CITY OF ALBUQUERQUE

**Re: Lot 16 Block 6 Unit 18 Volcano Cliffs, S.A.D. 228
6512 Kimmick Rd NW
Request Permanent C.O. – Not Accepted
Engineer's Stamp dated: 9-24-17 (D10D003M16)
Certification dated: Not Provided**

Based on the Certification received 2/26/2018, the site cannot be accepted for release of Certificate of Occupancy by Hydrology until the following comments are addressed.

MICHAEL SANCHEZ – CRUZ & BRENDA – GRADING & DRAINAGE PLAN

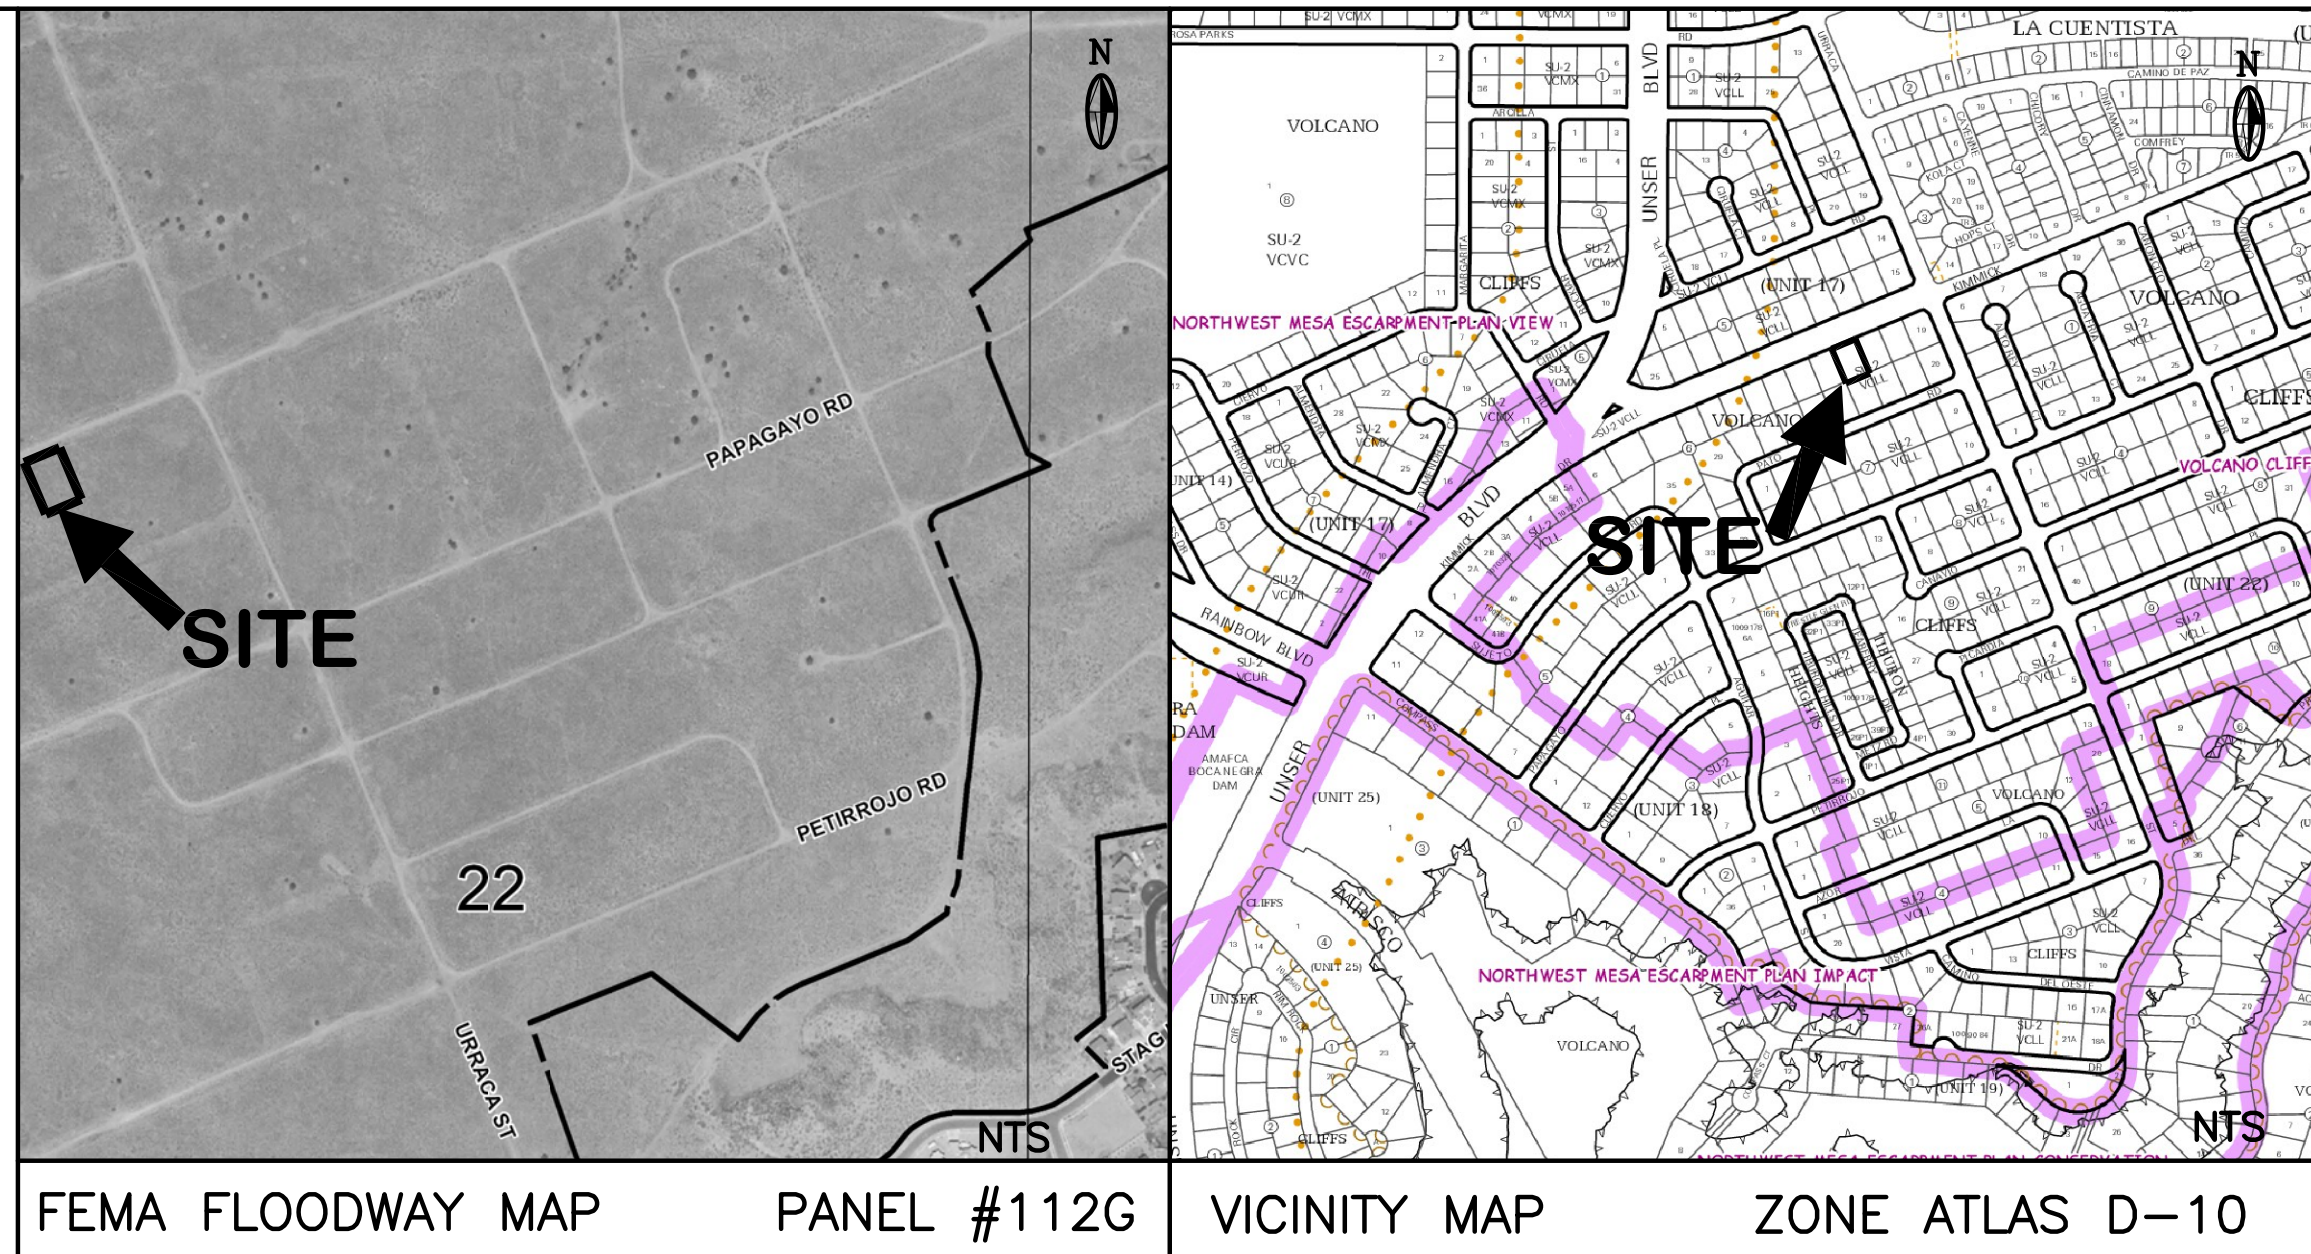
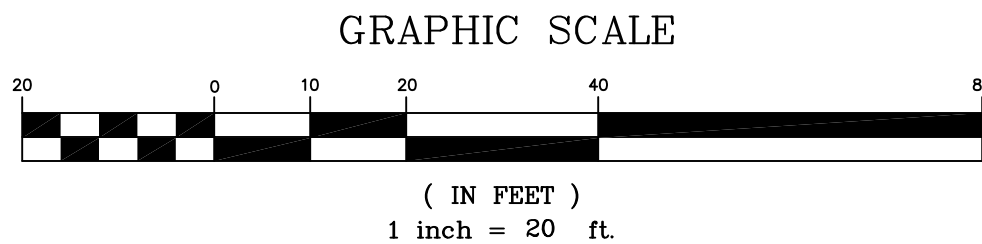
- Provide the Certificate of Occupancy statement on the plan.
